631.30507-L01-v0.1-20220401.docx

Response to Request for Information 42 Honeysuckle Drive Newcastle NSW 2300

Thank you for your letter which requested further information (RFI) related to the Modification Application (Mod) for SSD 10378 Mod 2 located at 42 Honeysuckle Drive, Newcastle NSW 2300.

Section Section BB-CC

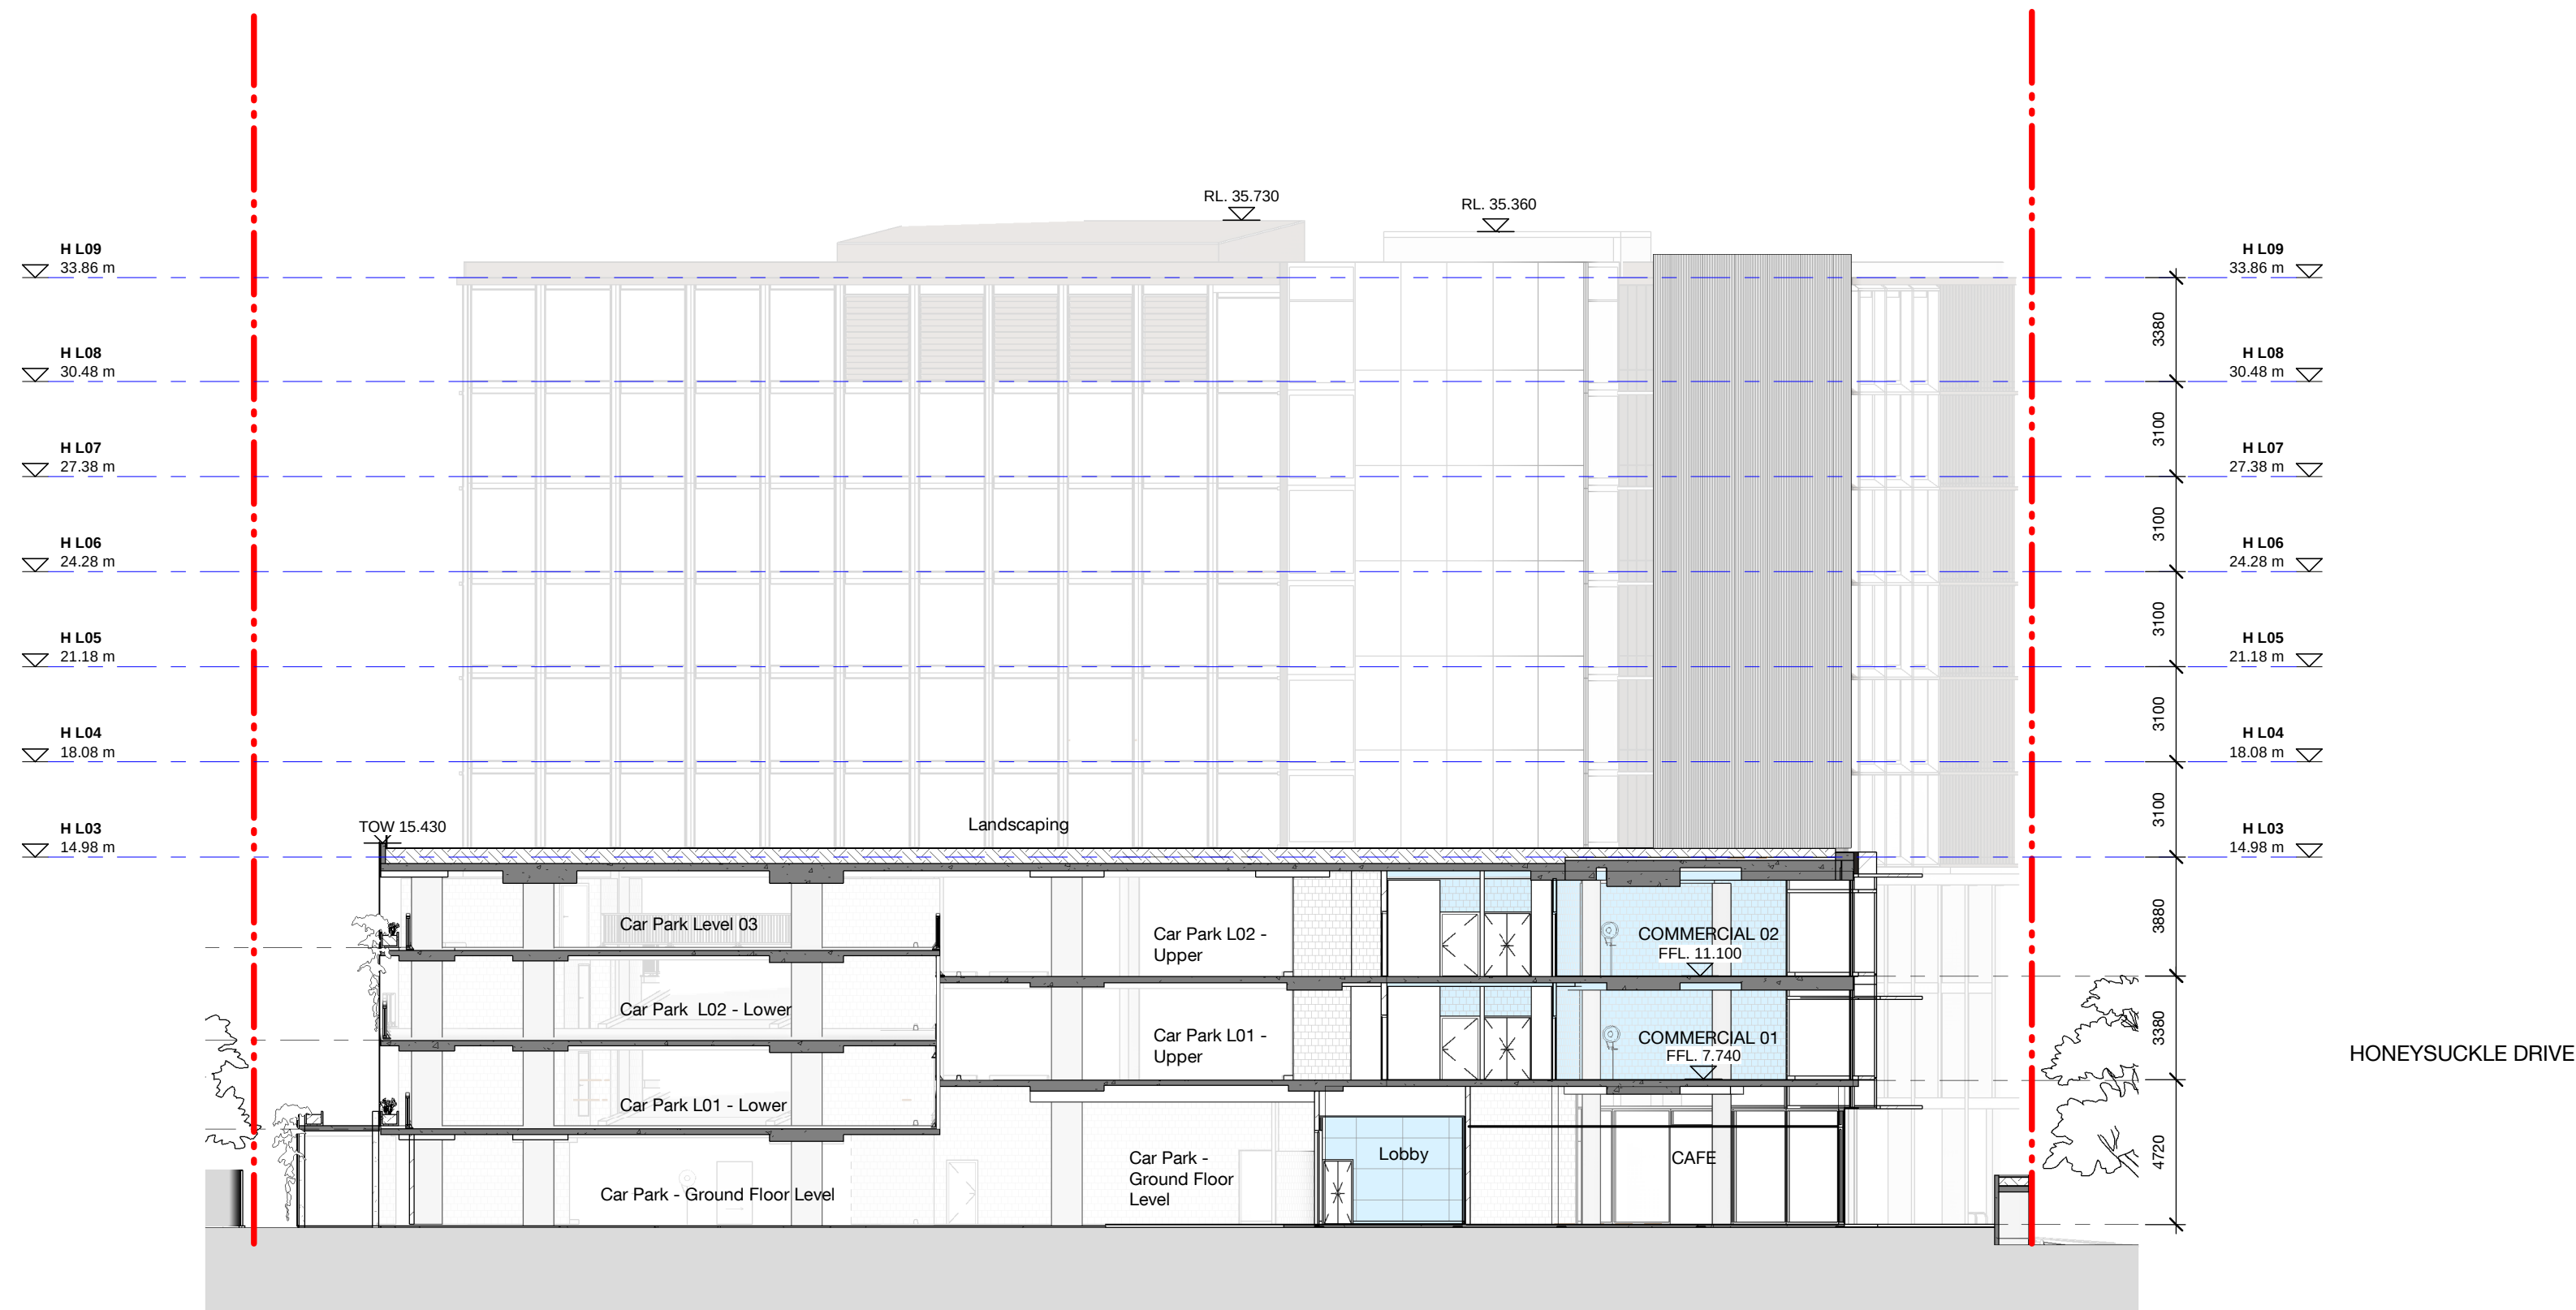
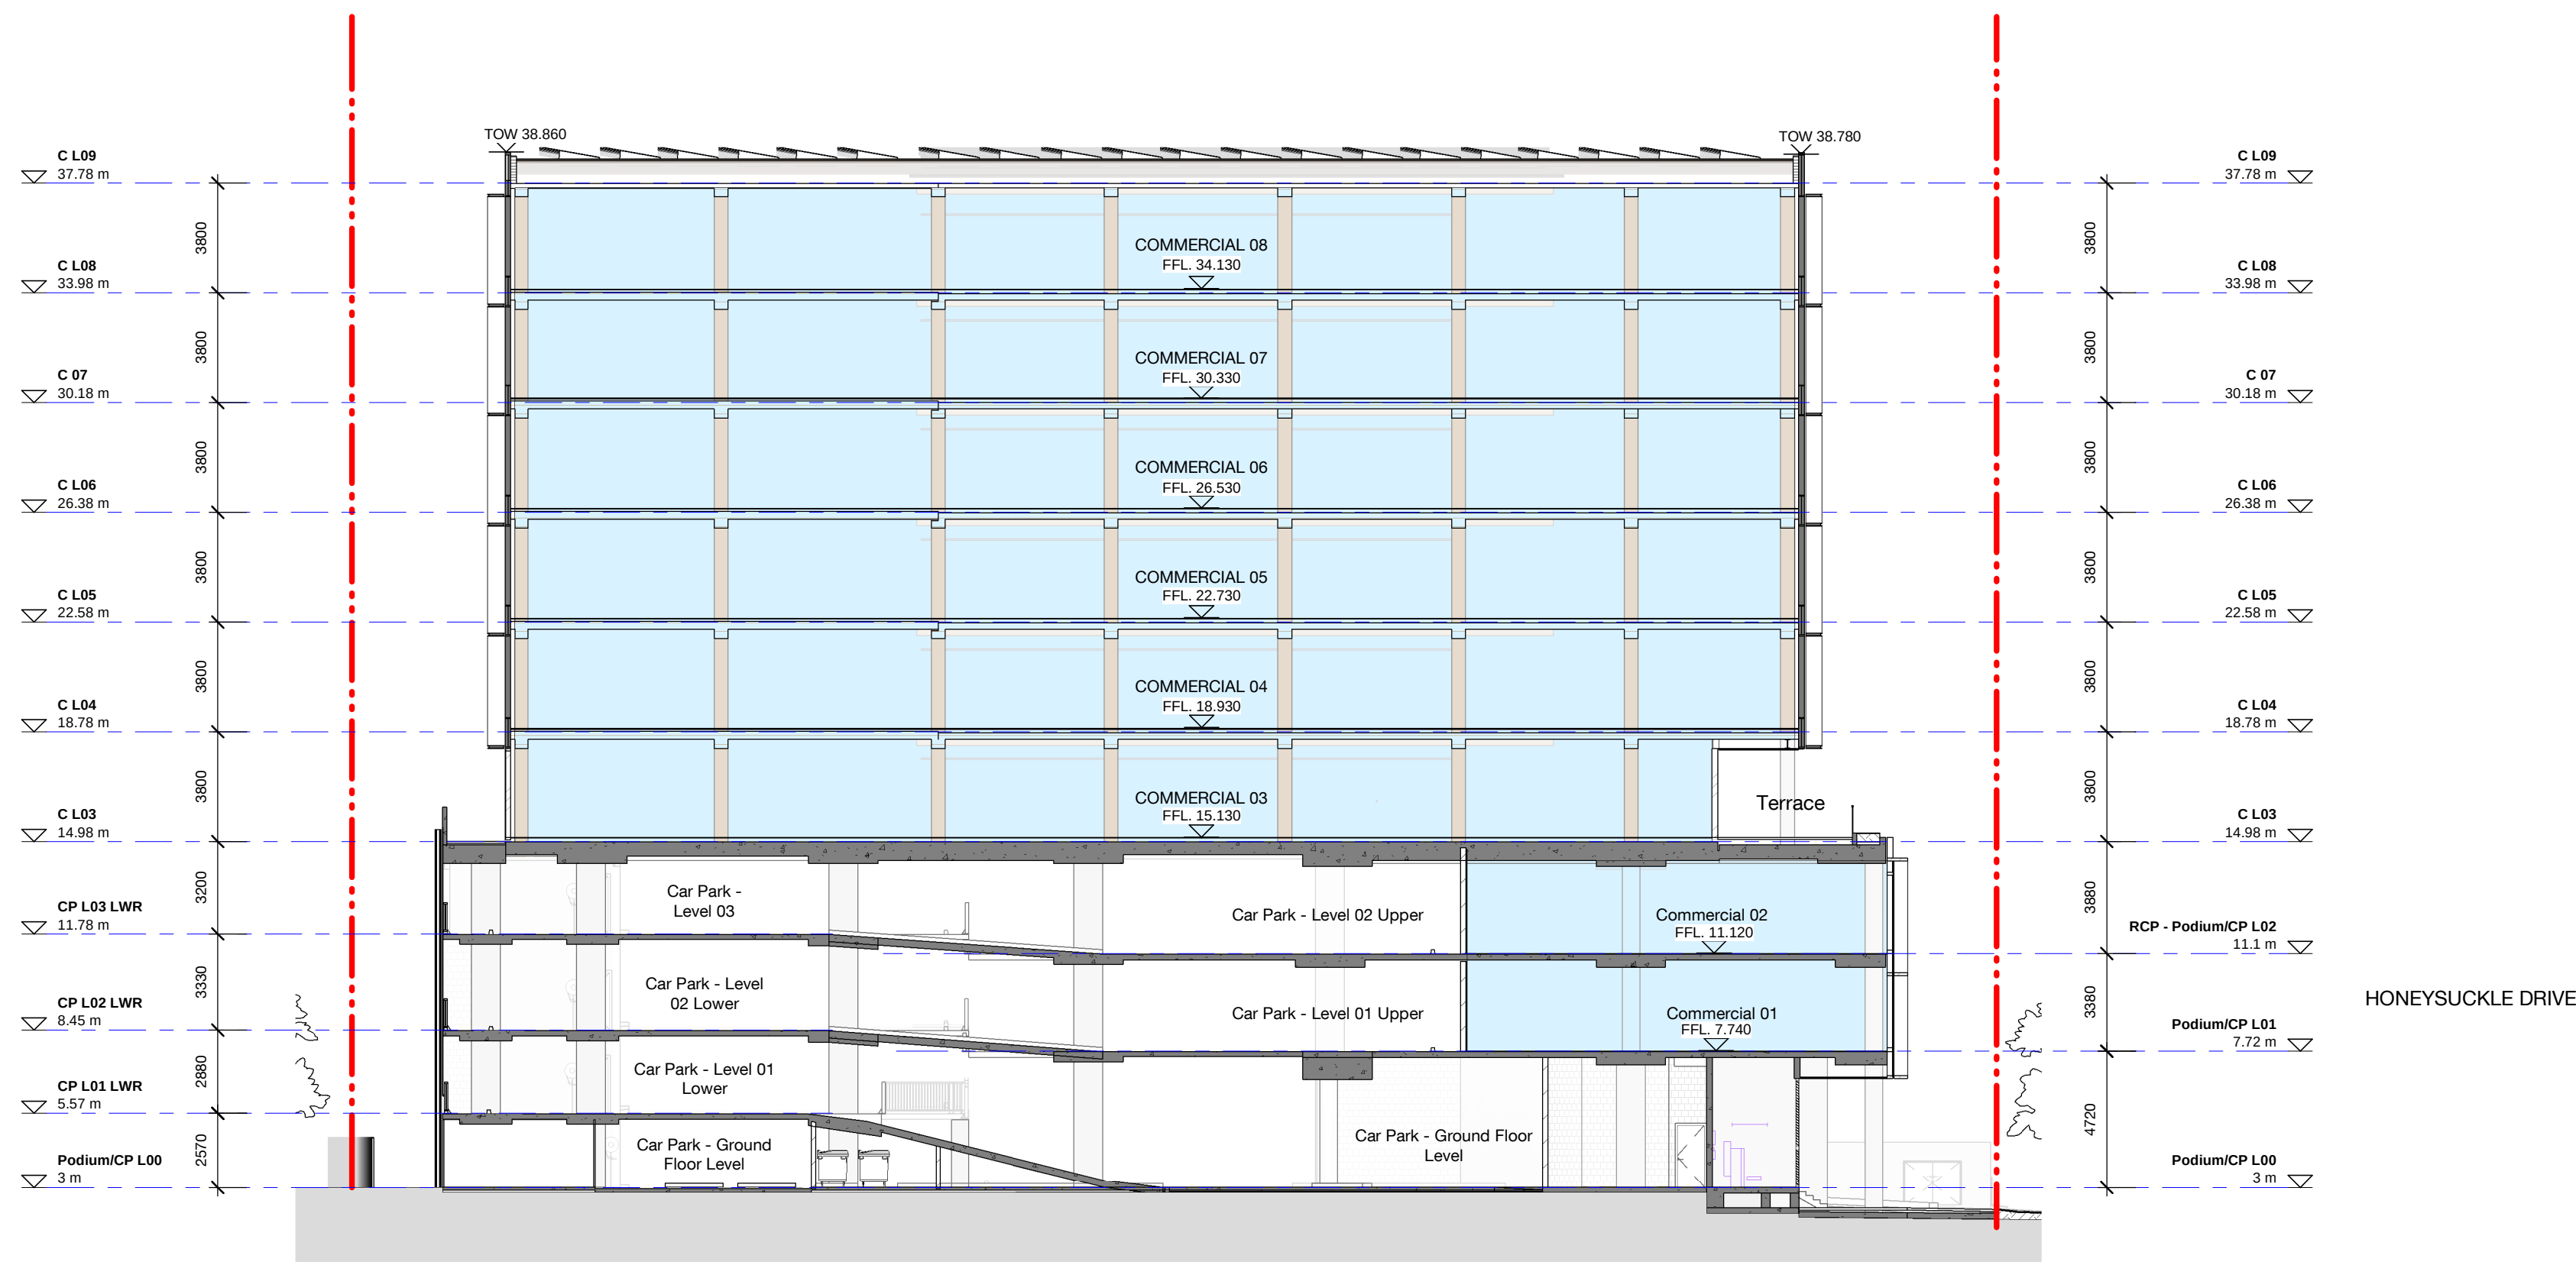
No acknowledgment and explanation are provided in the submitted documentation regarding the deletion of the section plans from Condition A2 of the development consent. It is recommended the applicant is required to provide modified section plans in support of the modification application.

Section plans have been provided as part of the Architectural Plans at Enclosure A.
